City of Portland, Maine - Building or Use Permit Application
 389 Congress Street, 04101 Tel: (207) 874-8703, Fax: (207) 874-8716

Permit No: 08-0468	Issue Date:	CBL: 272 B005001
------------------------------	--------------------	----------------------------

Past Use: Vacant Lot (demo permit #07-0945)	Proposed Use: Single Family Home - New 26' x 48' split level single family home	Permit Fee: \$1,825.00	Cost of Work: \$173,000.00	CEO District: 3
Proposed Project Description: New 26' x 48' split level single family home.		FIRE DEPT: <input type="checkbox"/> Approved <input type="checkbox"/> Denied	INSPECTION: Use Group: Type	
		Signature:	Signature:	
PEDESTRIAN ACTIVITIES DISTRICT (P.A.D.)				
Action <input type="checkbox"/> Approved <input type="checkbox"/> Approved w/Condition <input type="checkbox"/> Denied				
Signature: Date:

(SHEET C)

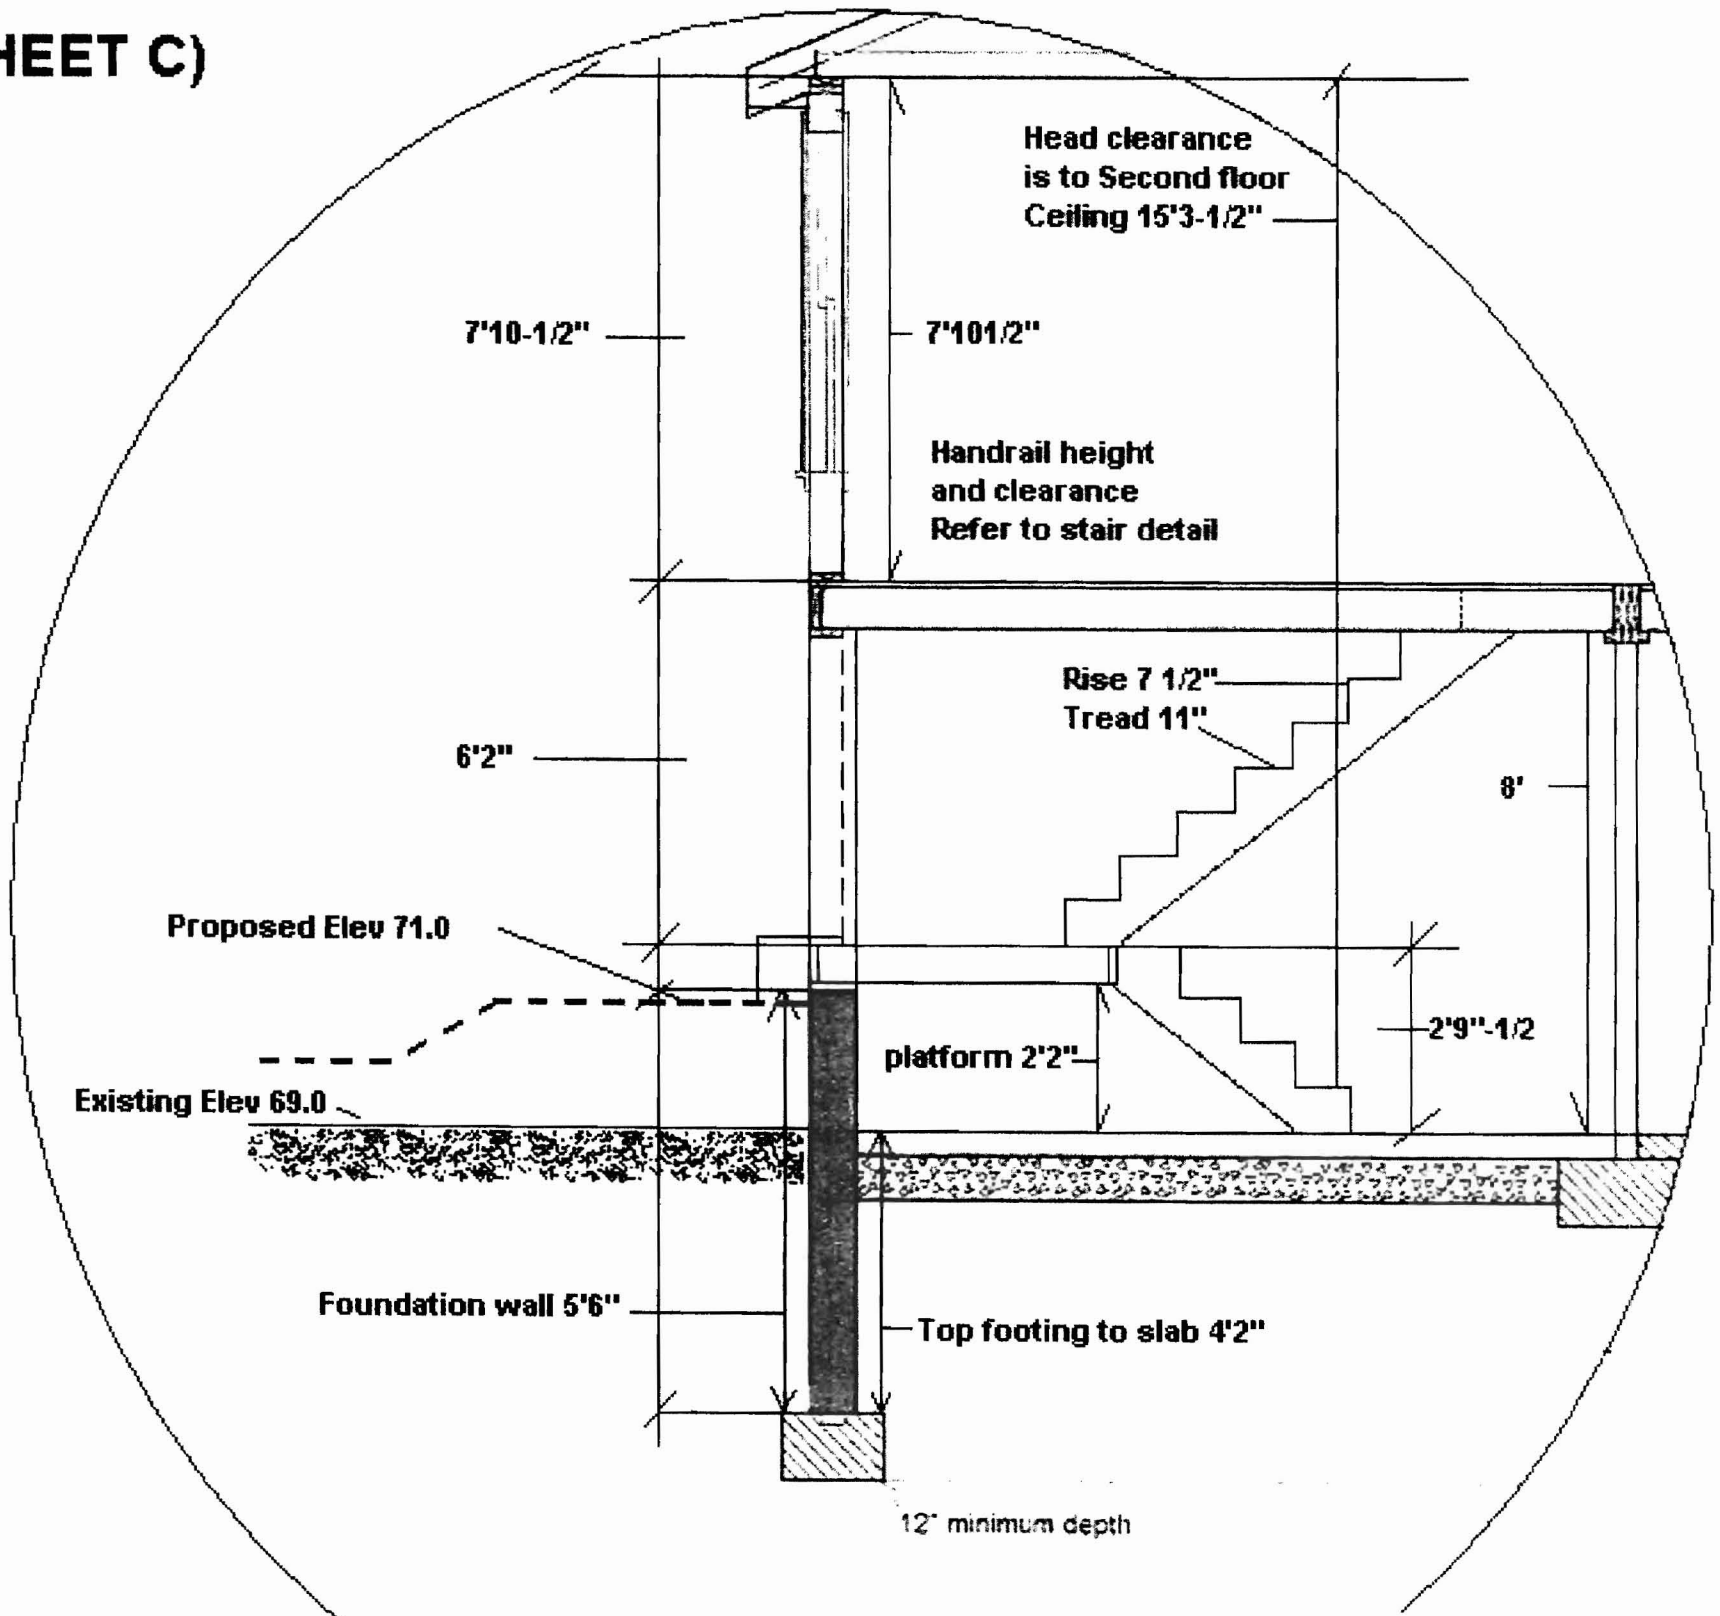
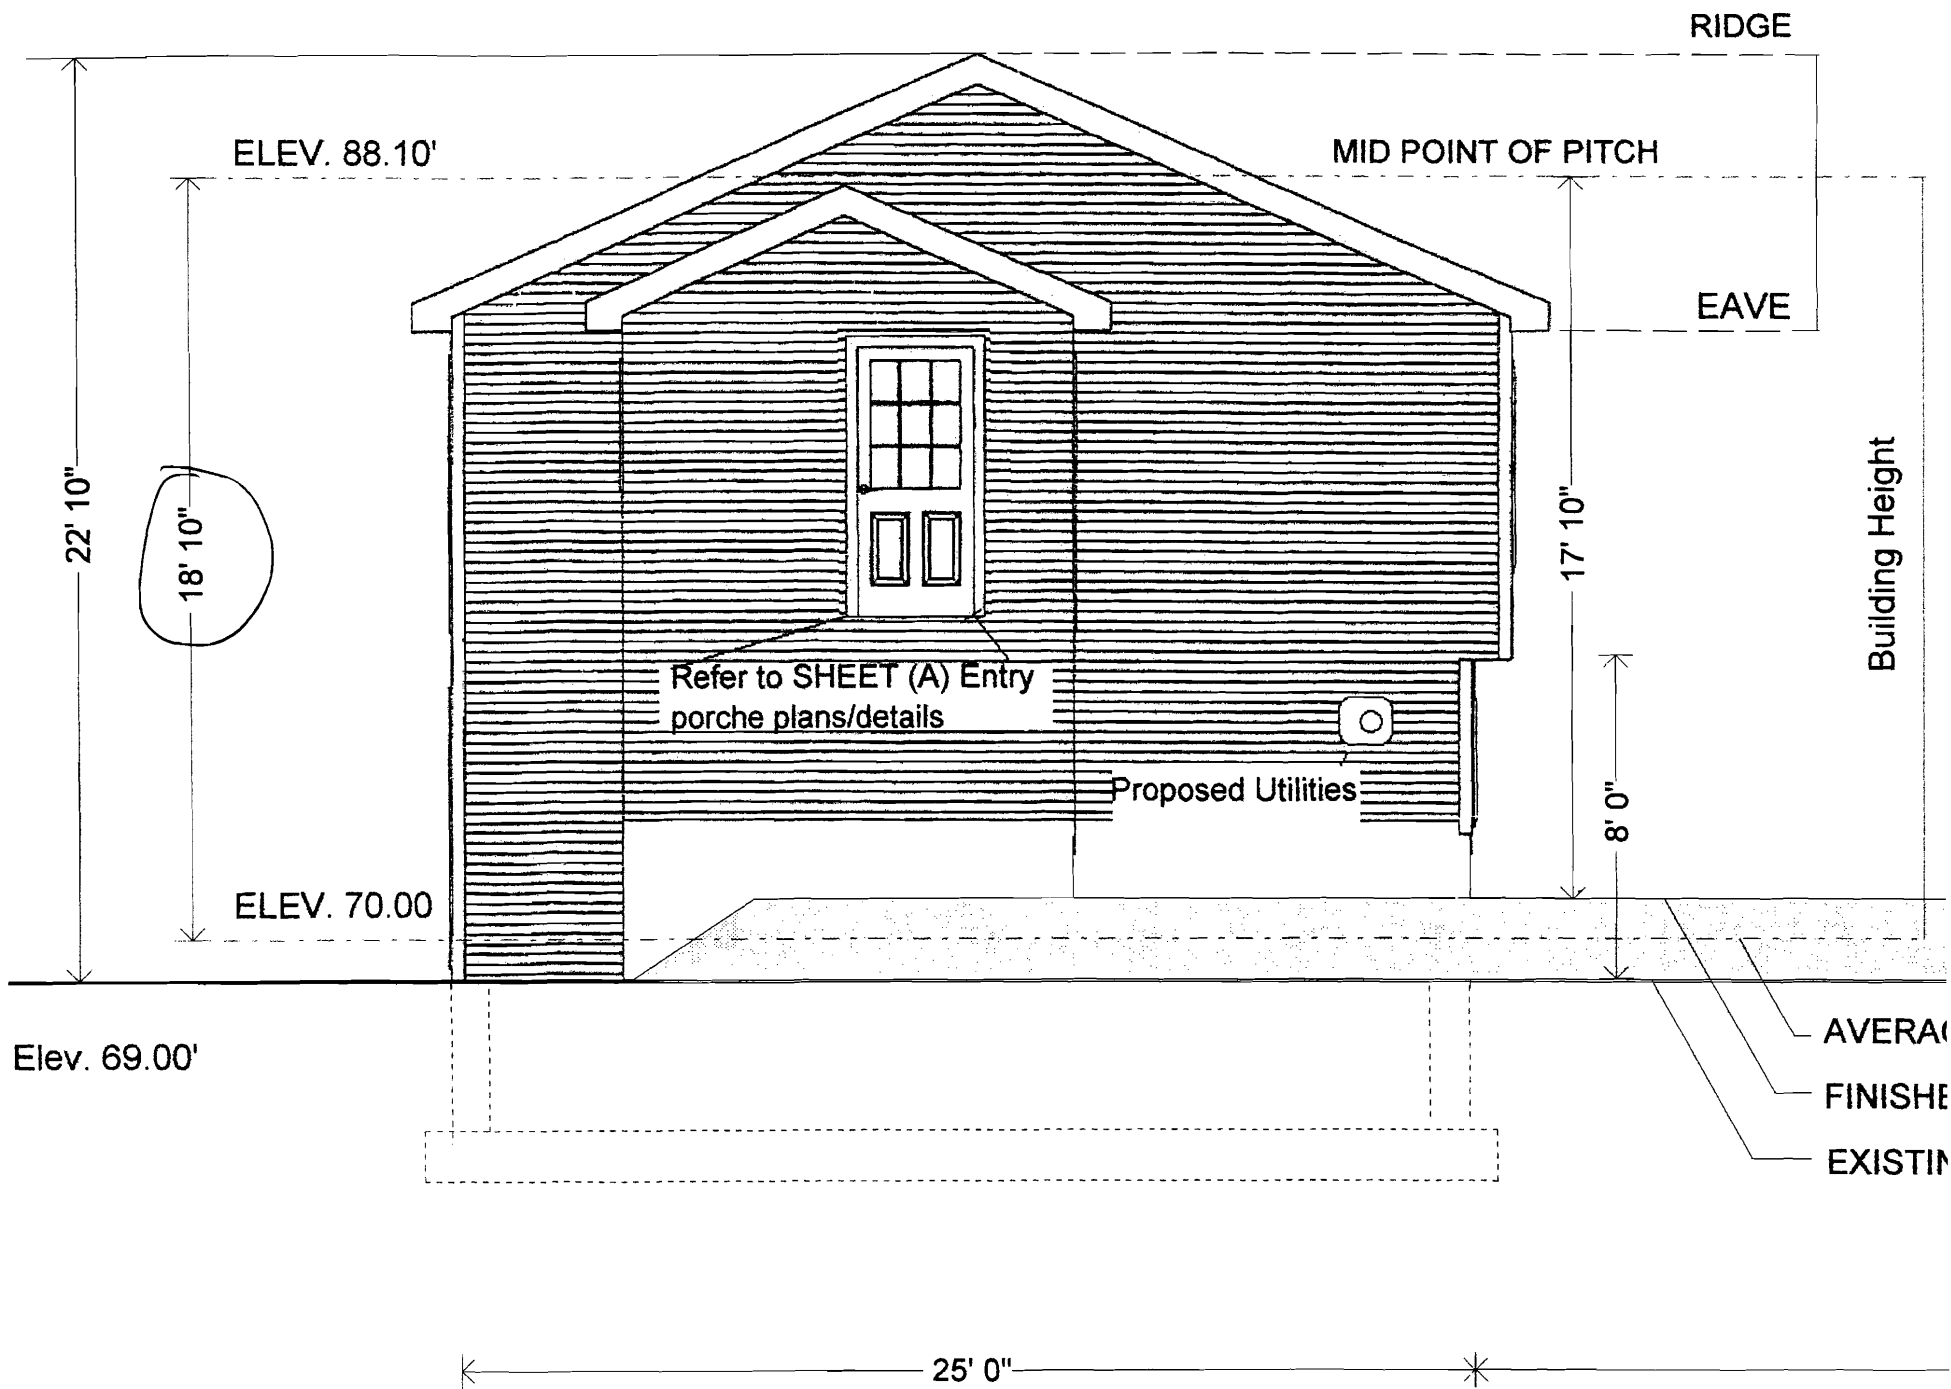
Note: Considering the house as two story since there was not enough information submitted to see if more than half of the bottom floor is above grade. **Ok to Issue:**

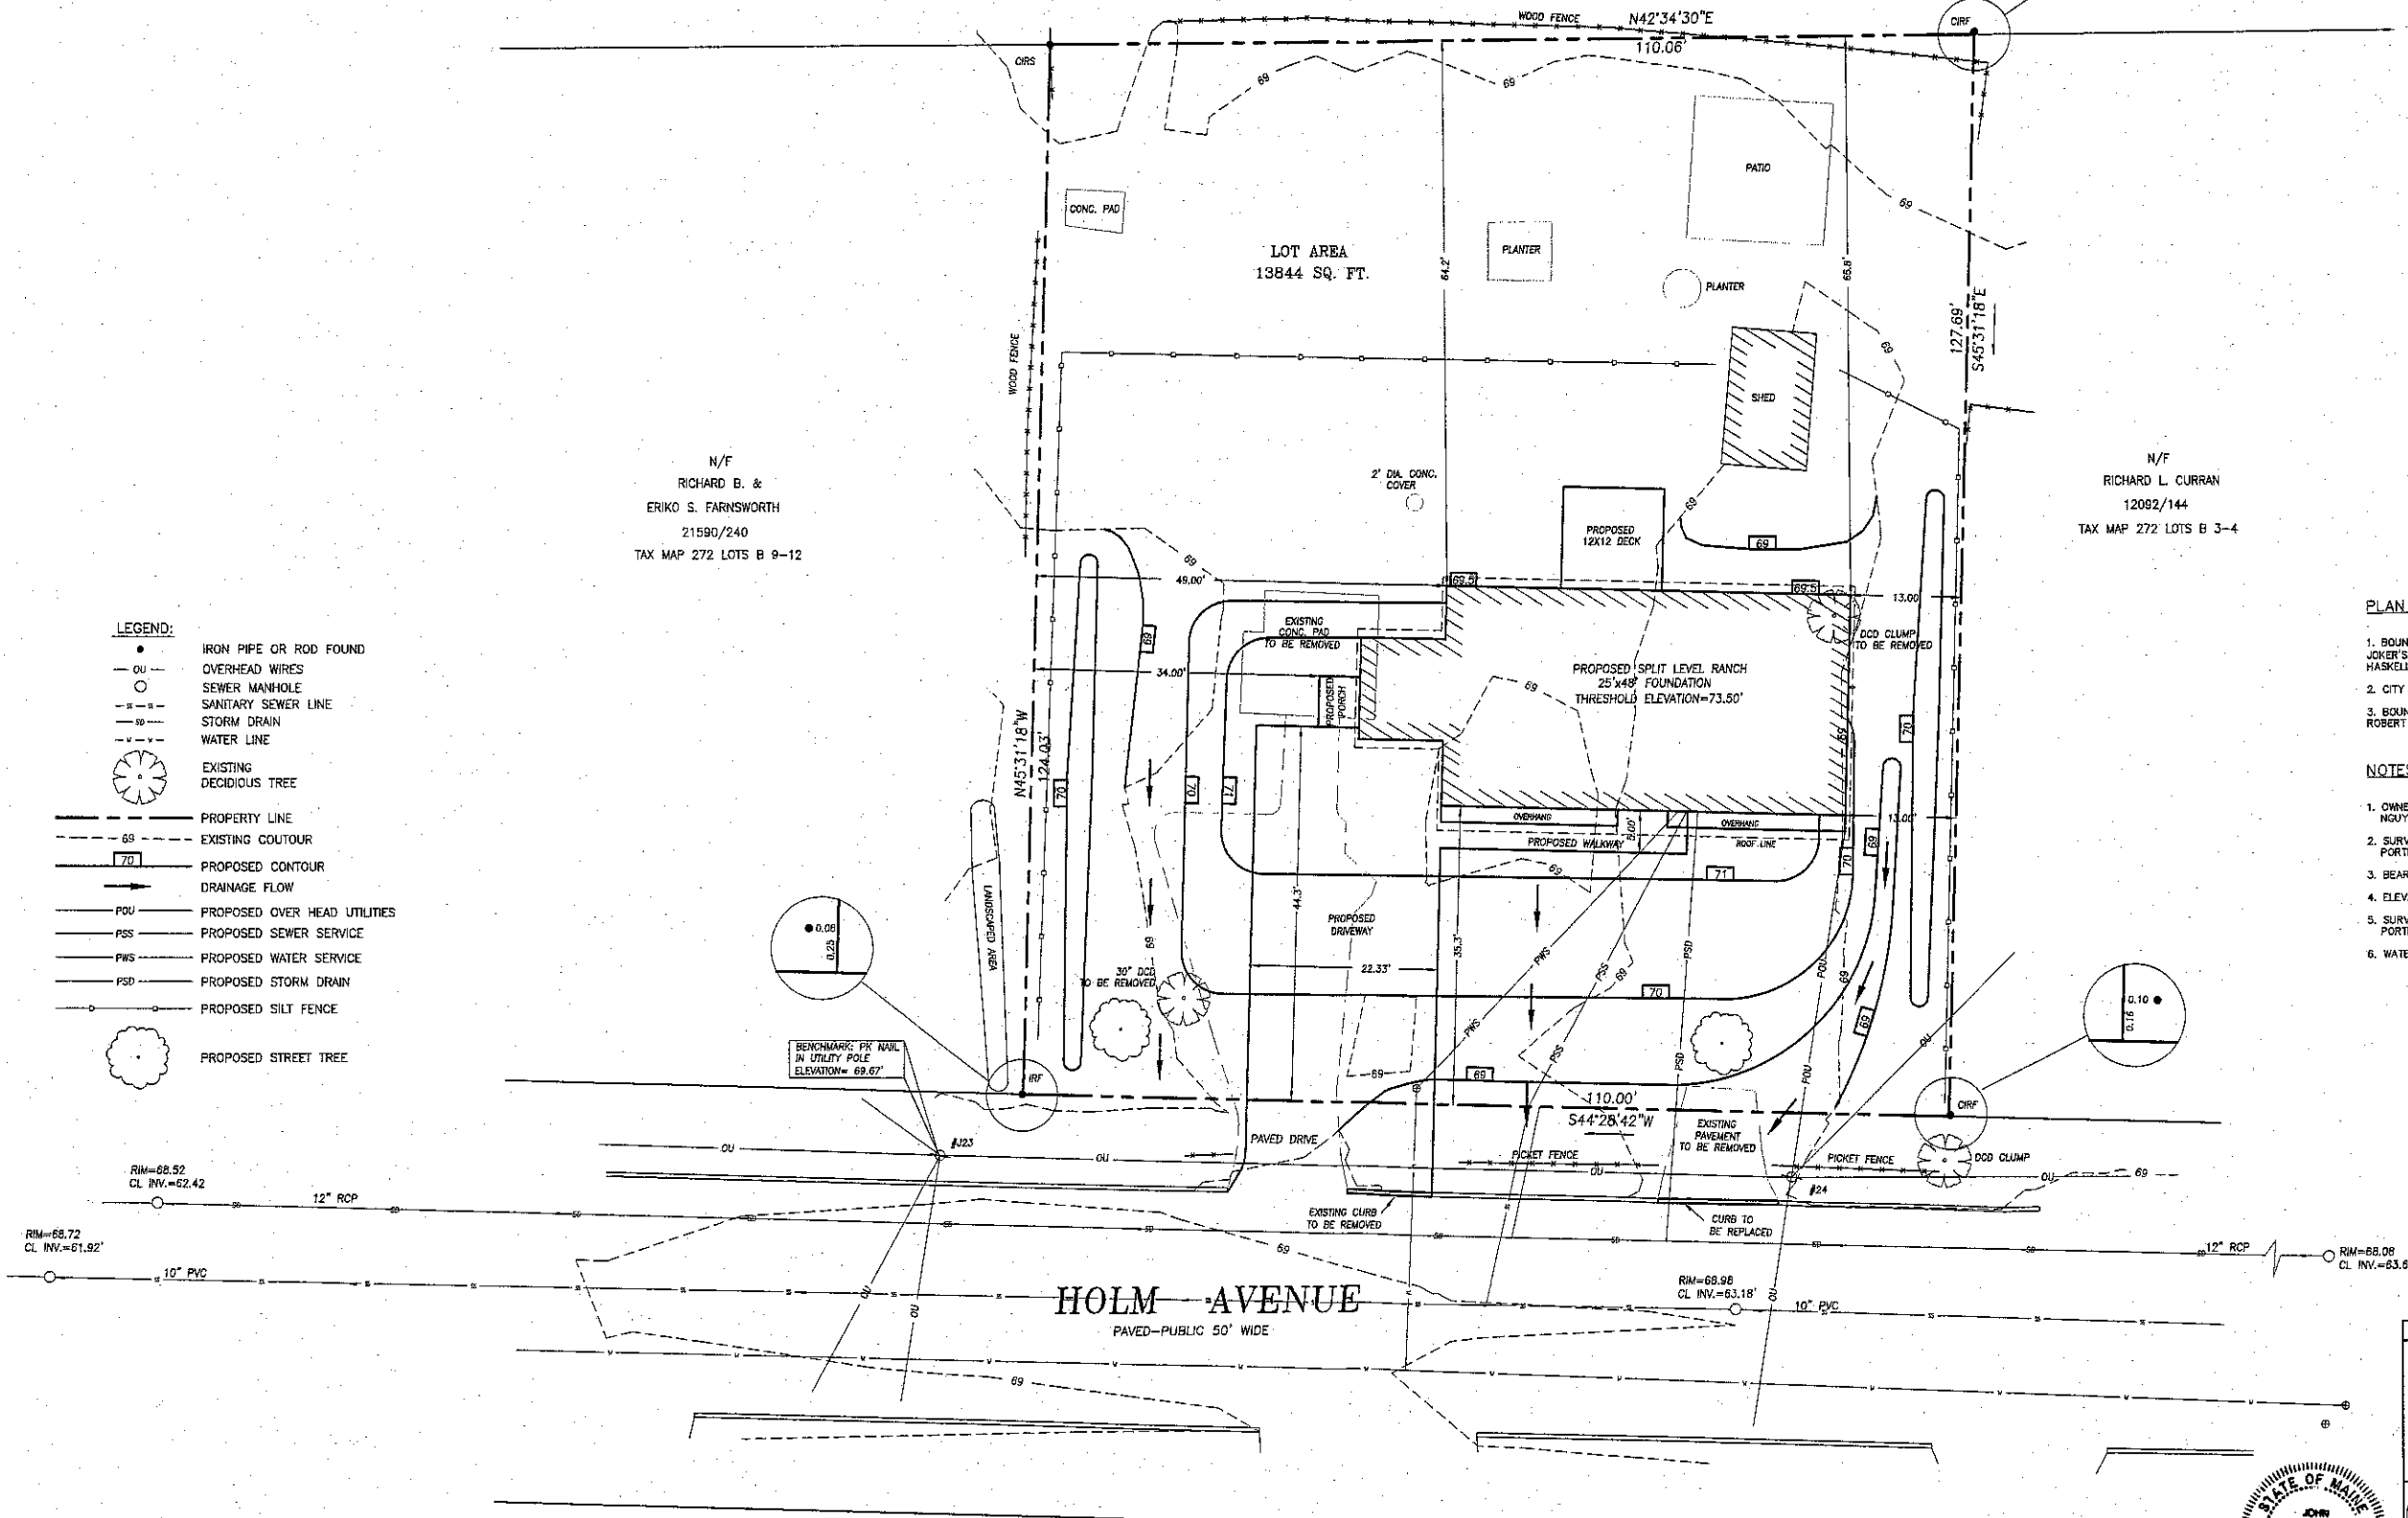
5/22/2008-pd: Spoke to agent, Robert Ahlemeyer, and asked him to provide more information on the site plan. The site plan needs to include existing and proposed grades, silt fence, utility connections ie. Water, sewer, foundation drain, electrical, need to include street trees, and need to close curb opening for second driveway. Finish grading for drainage is not clearly addressed on the existing site plan.
